perm. # 990659

BUILDING PERMIT REPORT

DATE: 23 June 99 ADDRESS: 286 Brackett St. CBL: 063-I-002
REASON FOR PERMIT: Re. Construct 22 1/2' x 8' deck, lower deck 4 1/2' x 4 1/2'
BUILDING OWNER: Deidre Coltrera
PERMIT APPLICANT: Matthew Piersol
USE GROUP R-3 BOCA 1996 CONSTRUCTION TYPE 53

STAIRS to Platform from Deck

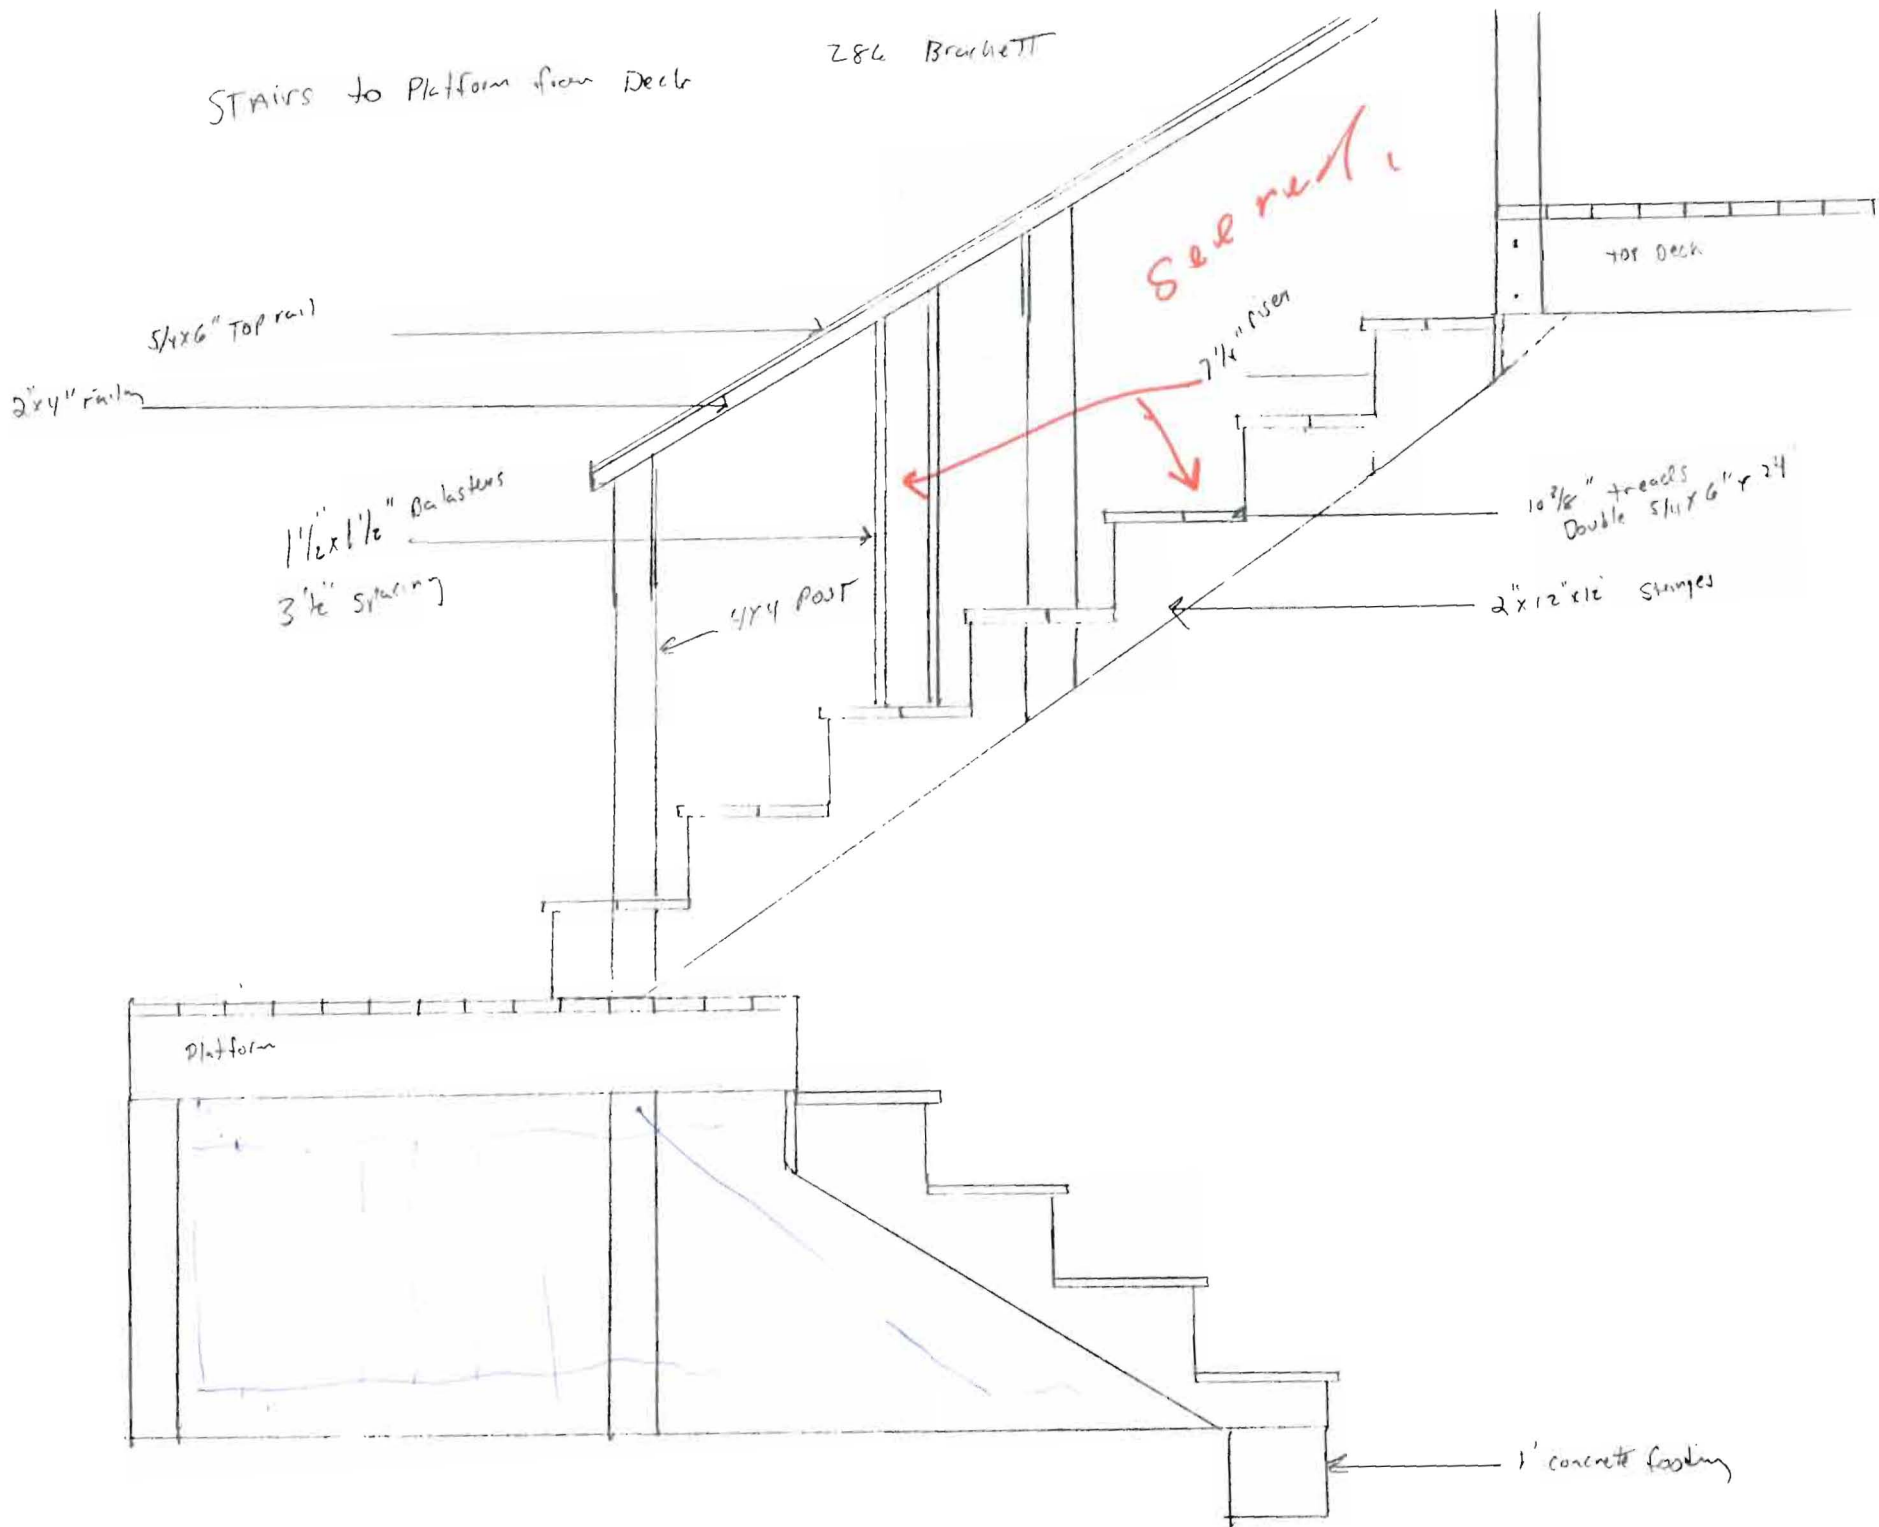
11/15/00 - Check seal hts + freights Risers - OK - appears to be same footprint as original - no spaces over 4 inches - soffits appear OK

Staircase - Lower Platform

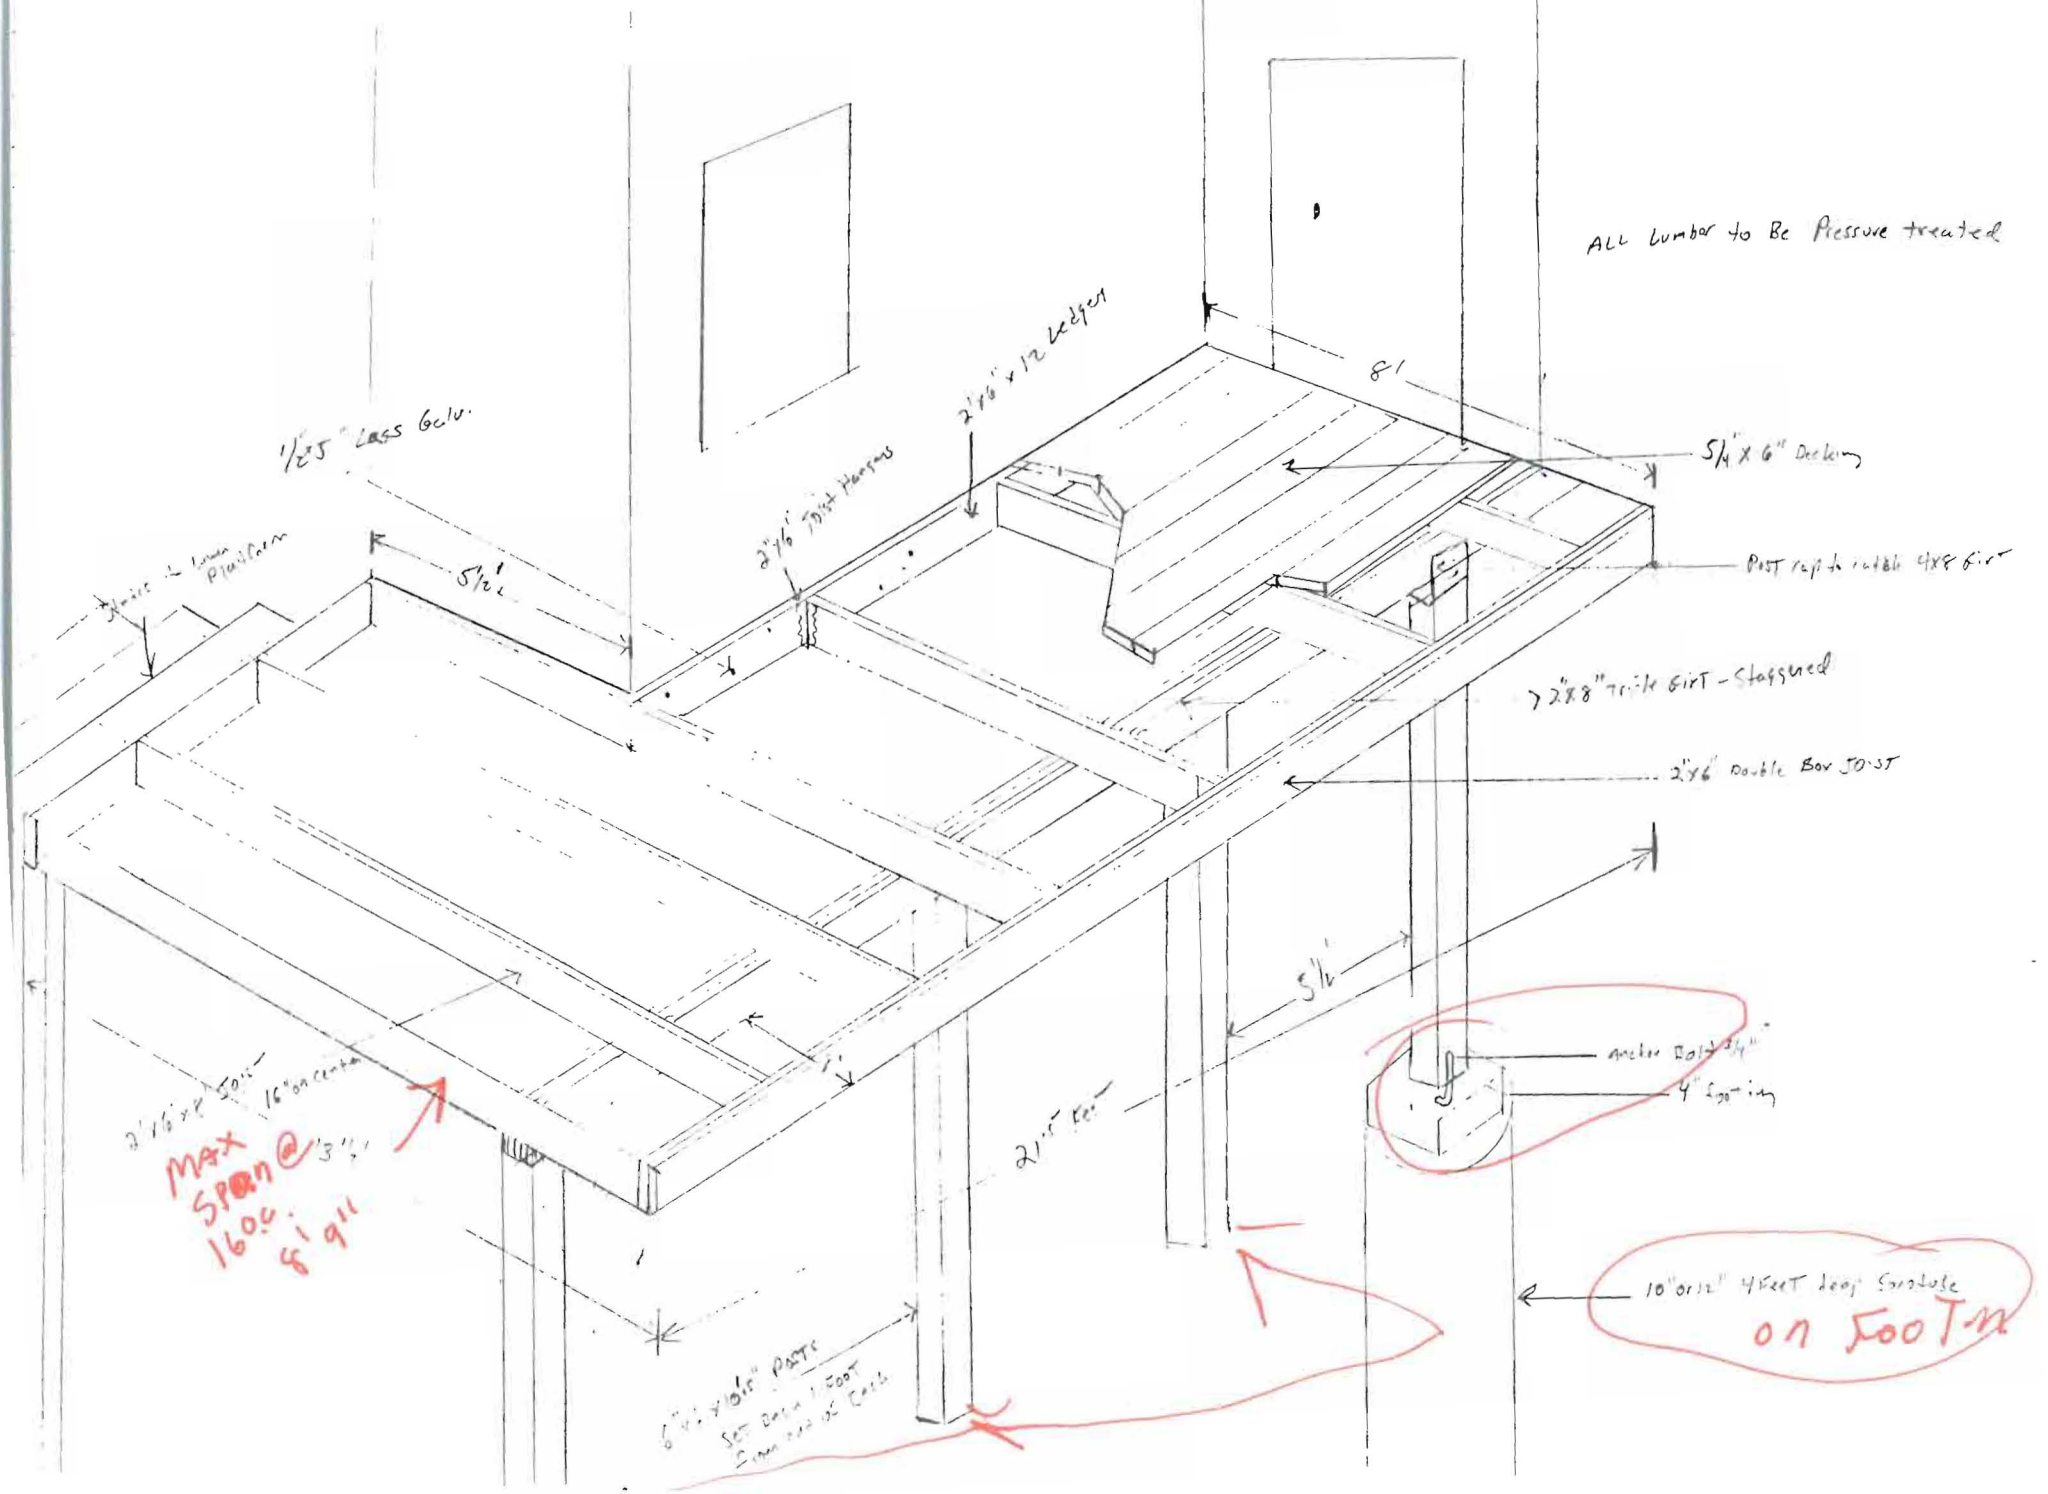
- X 35. MAX SPAN OF 2x6 @ 16" O.C. IS 8'9" -
- X 36. Proposed piers (Sono Tubes 10") shall be placed on Footing with anchor between pier and Footing
- X 37. Proposed Ledger attached to dwelling shall be lagged to building
